**HISTORIC BUILDINGS AND MONUMENTS COMMISSION FOR ENGLAND  
(HBMCE) COMMENTS ON APPLICANT'S RESPONSES TO HISTORIC  
ENGLAND RE: EXAMINING AUTHORITY'S  
QUESTIONS 01/04/2019**

**Highways England for an Order granting Development Consent for the  
A63  
Castle Street Improvement Scheme, Kingston Upon Hull**

**PINS Reference No: TR010016  
HBMCE Reference No: 20016278**

PROPOSED UTILITY DIVERSION

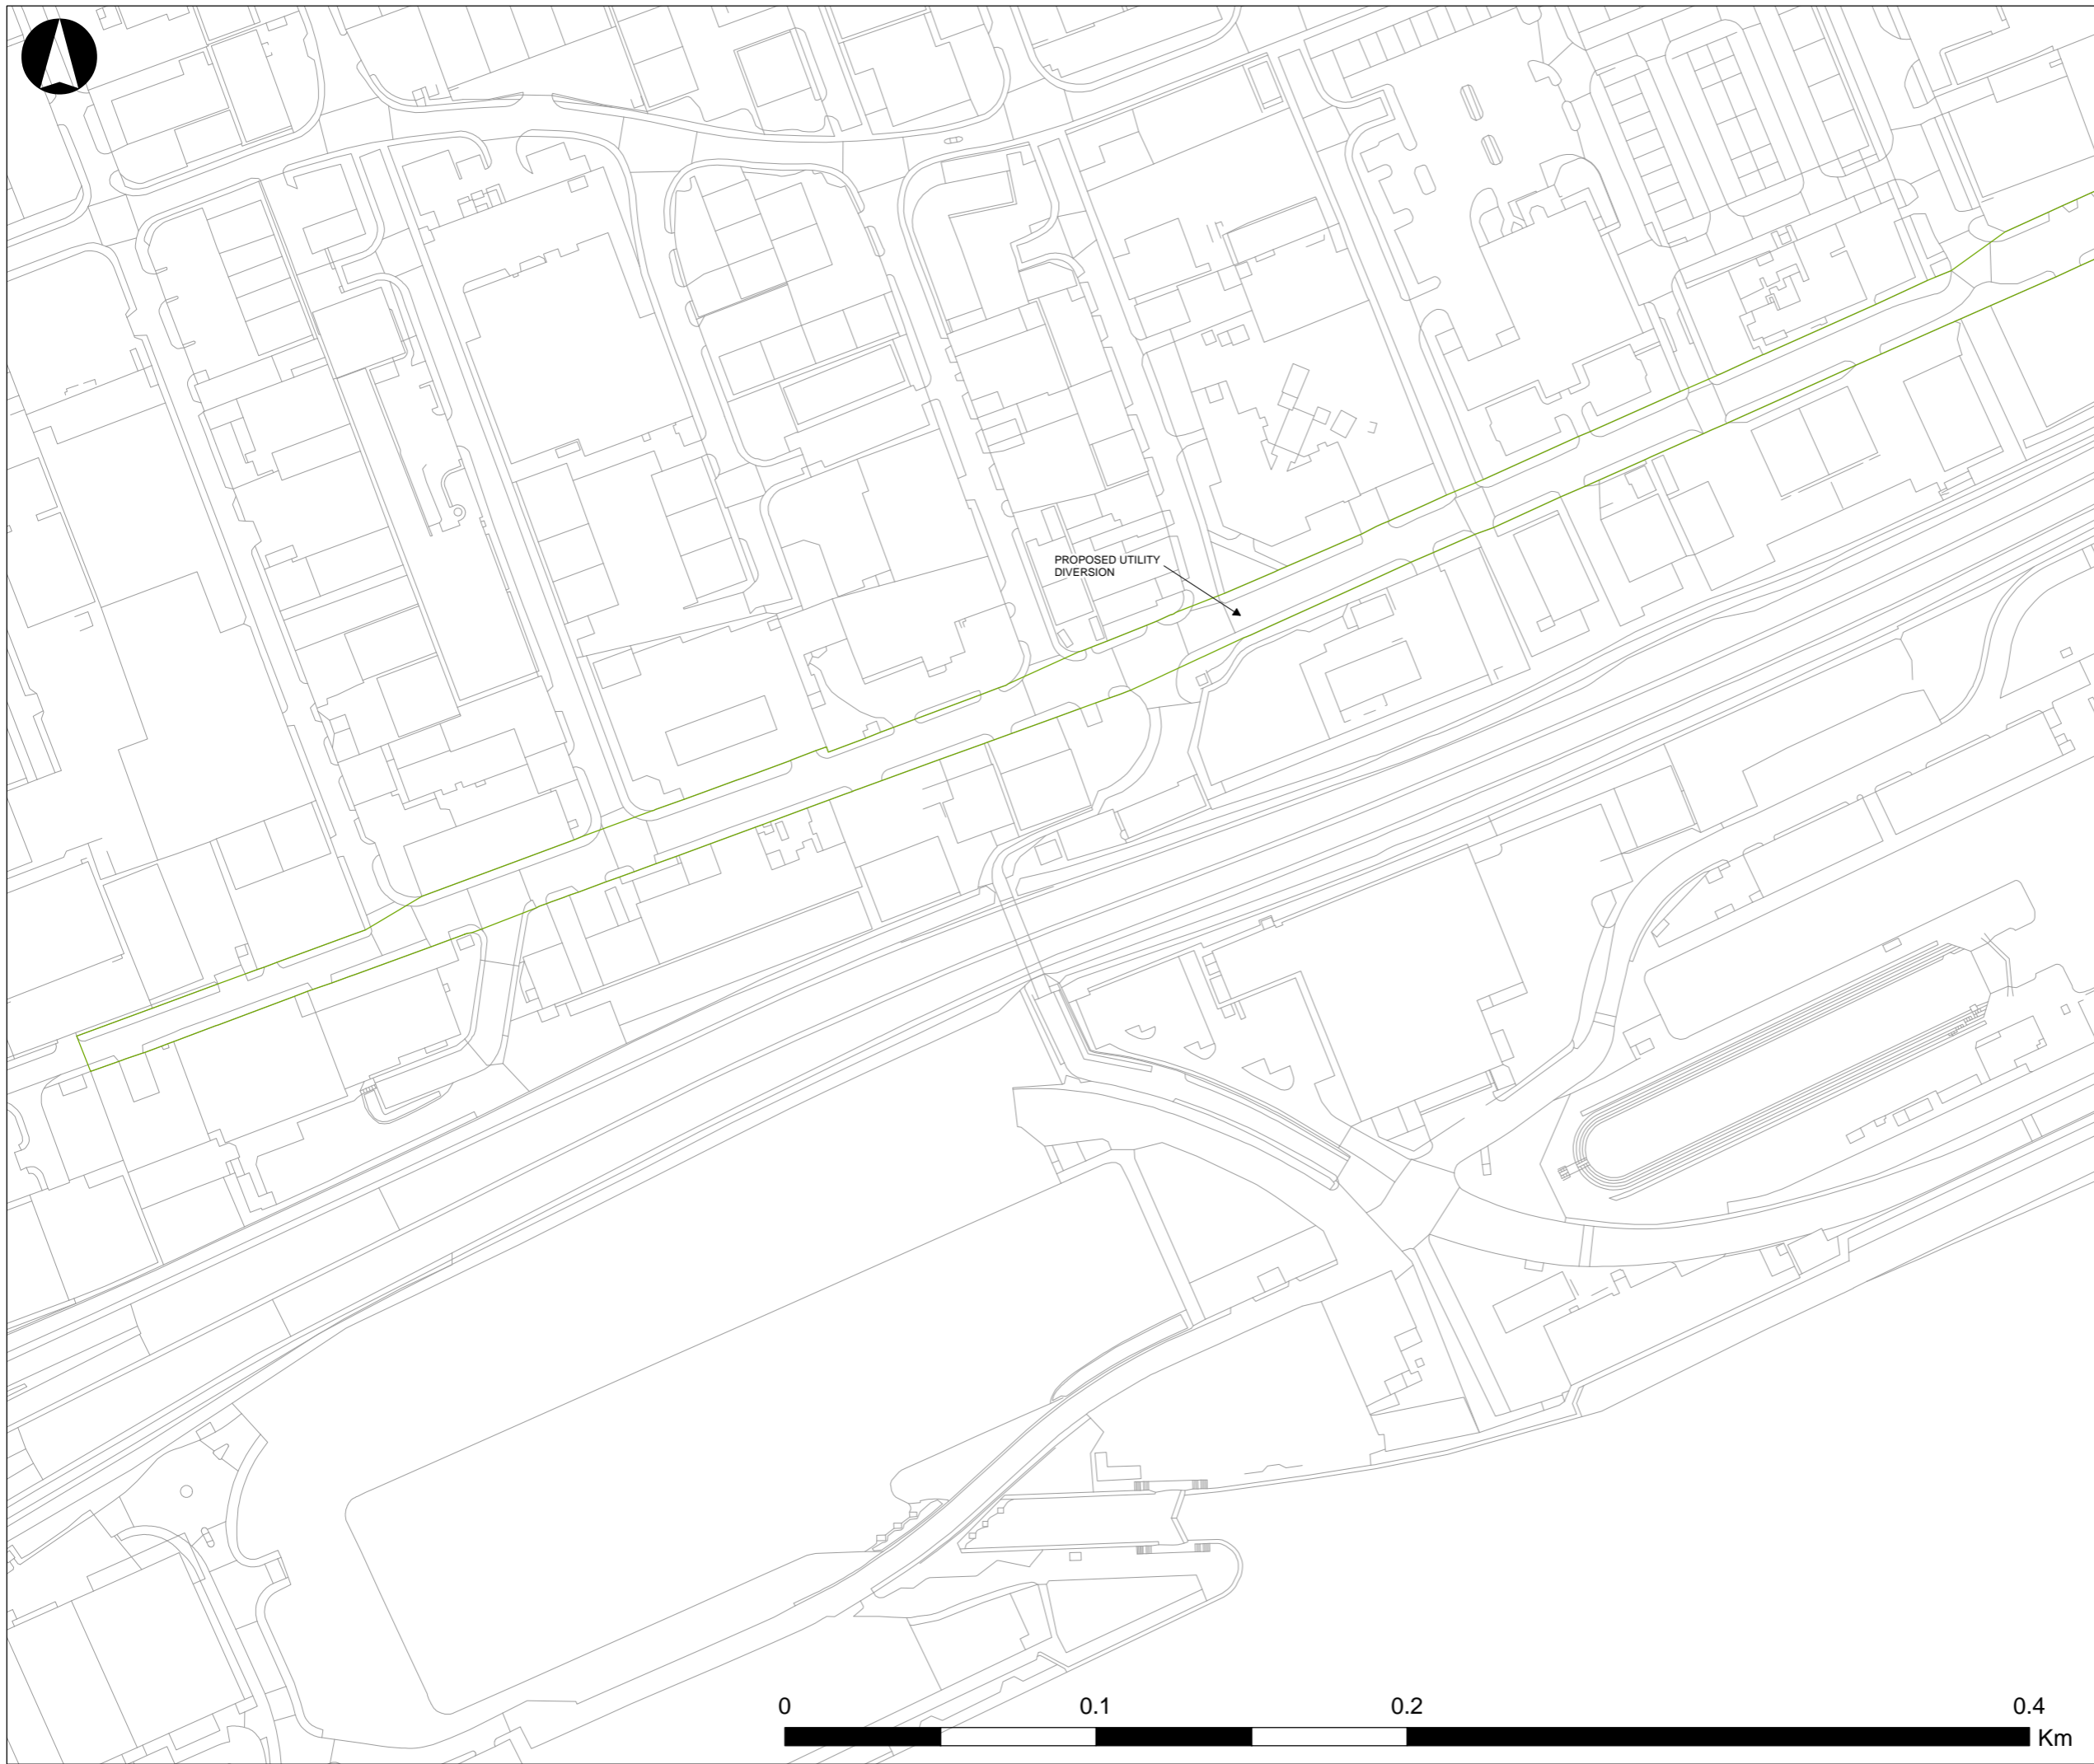
We note that Highways England do not plan to conduct works that will impact on the sunken display portion of the Beverley Gate scheduled monument. However, the scheduled area is in excess of double the size (in area) of the sunken display space and therefore we still require clarification about the nature of any works within the scheduled monument.

Whilst noting that the suggested works to the Beverley Gate are connected to the redirection of services and may therefore be contained within the uppermost 0.5m, the lack of any detail about what might be proposed, at what depth and in which location is a matter of considerable concern, and should be clarified as soon as possible in order to redesign the proposal, develop any necessary mitigation and to avoid harm to the significance of a designated heritage asset.

We note the further reference to works 'in the vicinity of Beverley gate', and the general description of the works that might take place but as identified above in our initial response to the question, the detail of these works to the scheduled monument need to be set out and we remain unclear as to the extent to which there could be an impact on the scheduled monument (either directly or through development in its setting. We would therefore advise that further information is forthcoming on this point and we would be pleased to consider these details and advise further when this information is forthcoming.

Initial enquiries with utilities have identified that a KCOM for the scheme. This has identified an option for diverting the existing cables running along the northern footway of the A63 in the vicinity of the Princes Quay bridge. The option identifies the diversion of the cables via Anlaby Road and Beverley Gate. This route would require a new cable being pulled along the existing network in Anlaby Road, around Beverley Gate and into Princes Dock Street. A new duct run would be required for reconnection the network with the existing cables running from Princes Dock Street towards Market Place. It is believed that there is adequate spare capacity in the existing duct network in Anlaby Road and round Beverley Gate to accommodate the cables required.

During the detailed estimates (C4) stage these works will be finalised and confirmation on any works required in this area will be agreed with the understanding that unless there is sufficient capacity for the new cable to run in the existing duct network another alternative route may be required. This will therefore minimise any excavation works required in the vicinity of Beverley Gate, apart from the connection in Princes Dock street to the existing network.

The diversion are fibre cables and therefore the most likely outcome is two way ducts if required to divert the service. A 450mm wide trench would be the most likely solution if this is the case.
